Anita Gardner
Principal Planning Officer,
Directorate of Place

Please find attached our letter responding to the 12 points listed above to be reconciled and supporting calculations and drawings.

I have the following comments regarding condition 3- surface water drainage:

DRAWING TITLE:
PROPOSED
IMPERMEABLE AREAS
SHEET 1

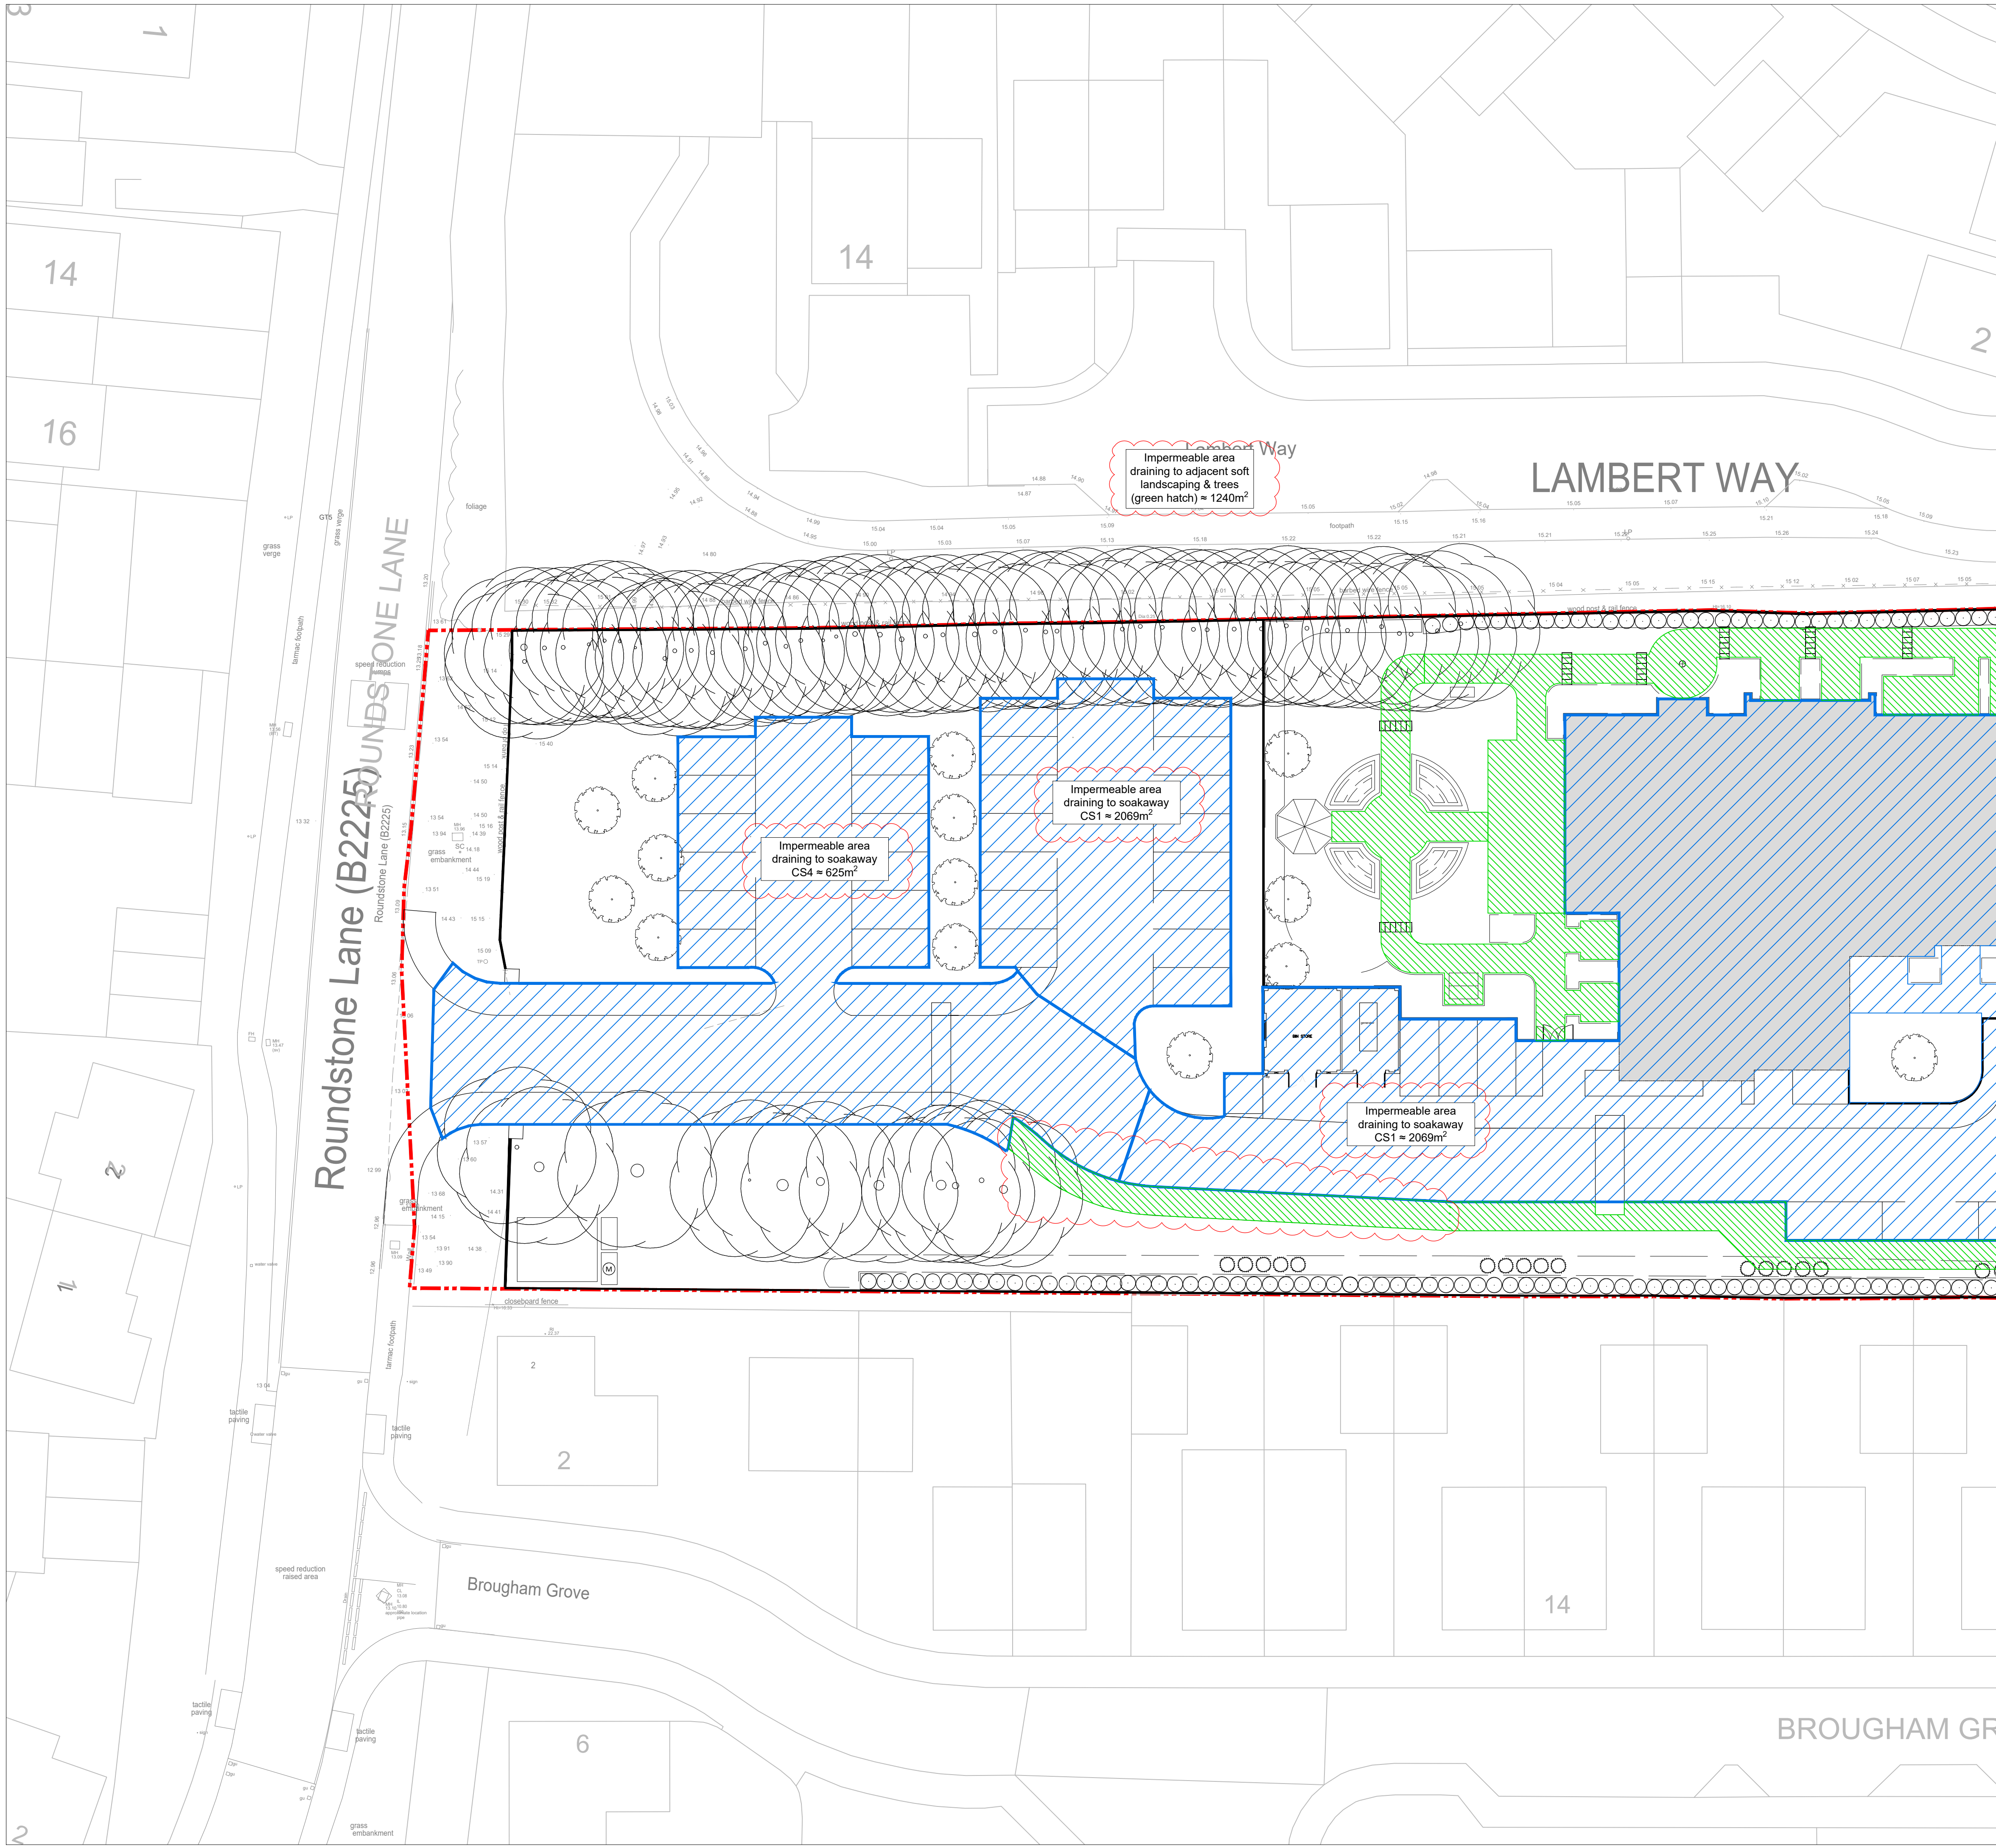
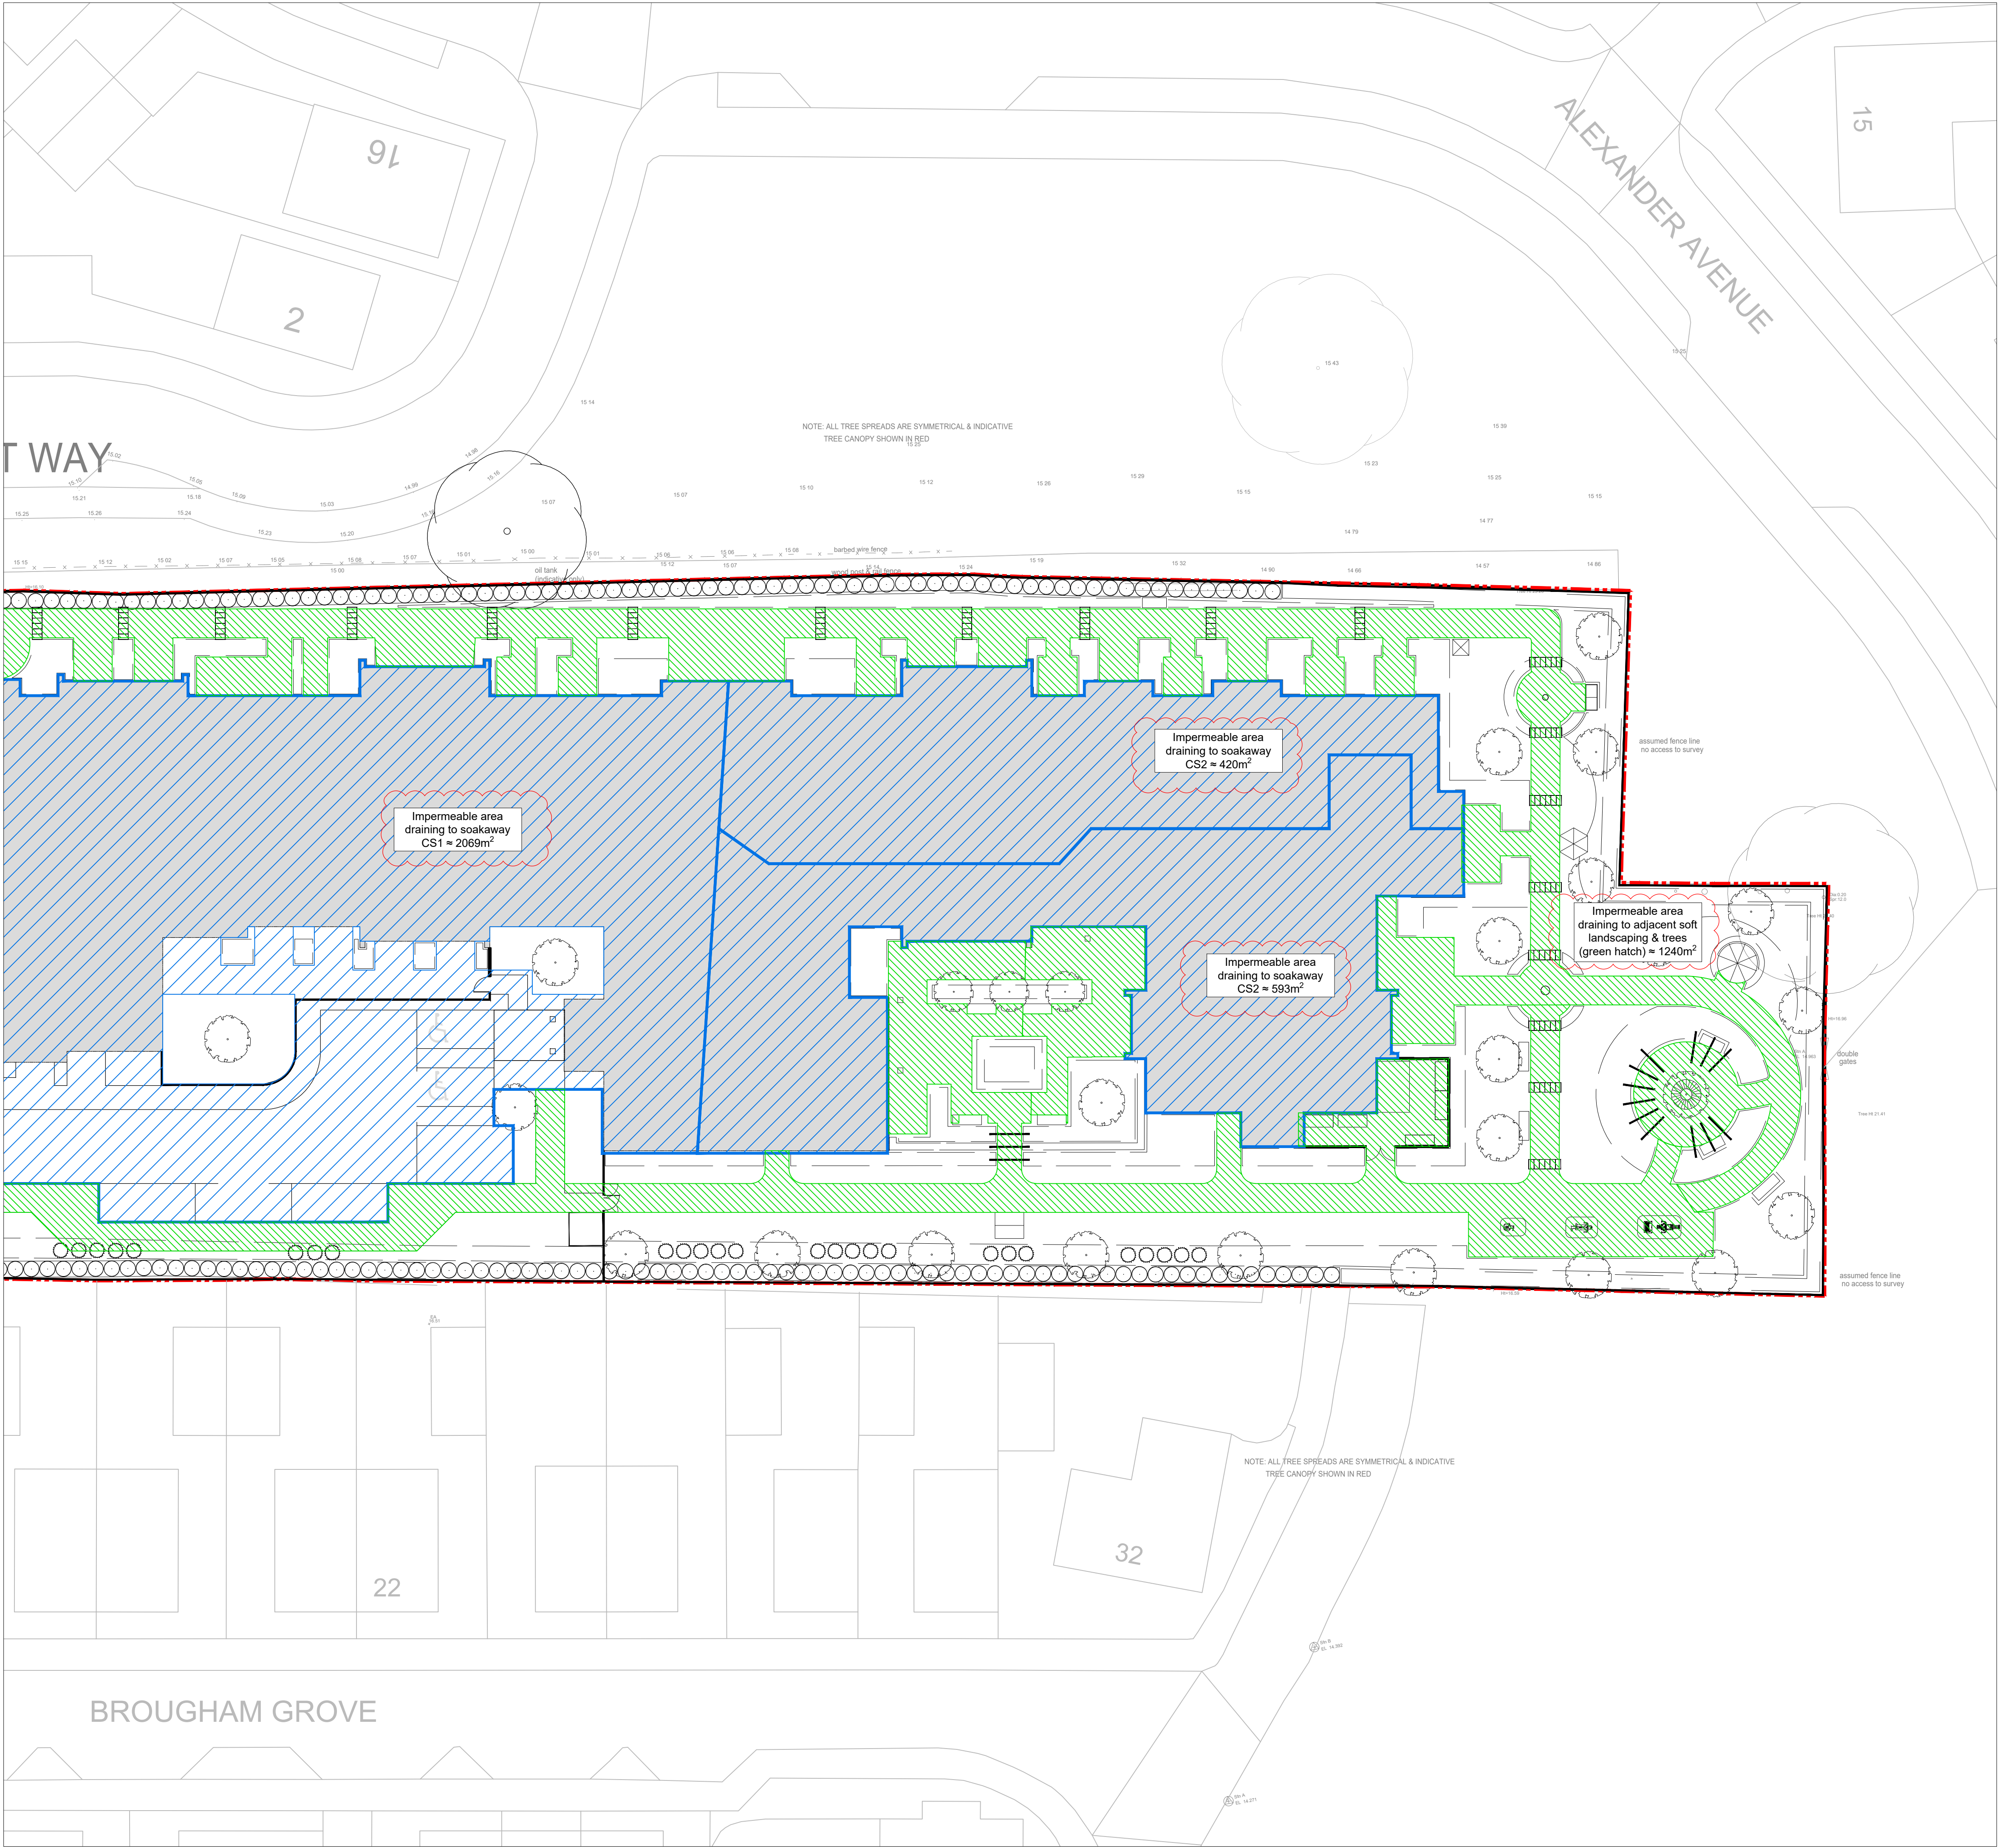
1. Please detail finish and formation levels of permeable paving on plans. I note that there are boxes that state "formation level approx. 0.5m from finished levels" but this is not accurate enough. Please provide spot levels as per drawings submitted for the previous approval.
2. Please provide a revised catchment area plan.
3. Porosity of soakaways in calculations is set to 1, please correct to 0.95 as per standard for crates.
4. Please provide invert levels of diffuser blocks on plan. Please detail diameter of pipes connecting from these to network on plan.
5. Please detail cover level of gullies.
6. The majority of cover levels and invert levels in SW network 1 are inconsistent between plans and calculations, please review and ensure consistency.
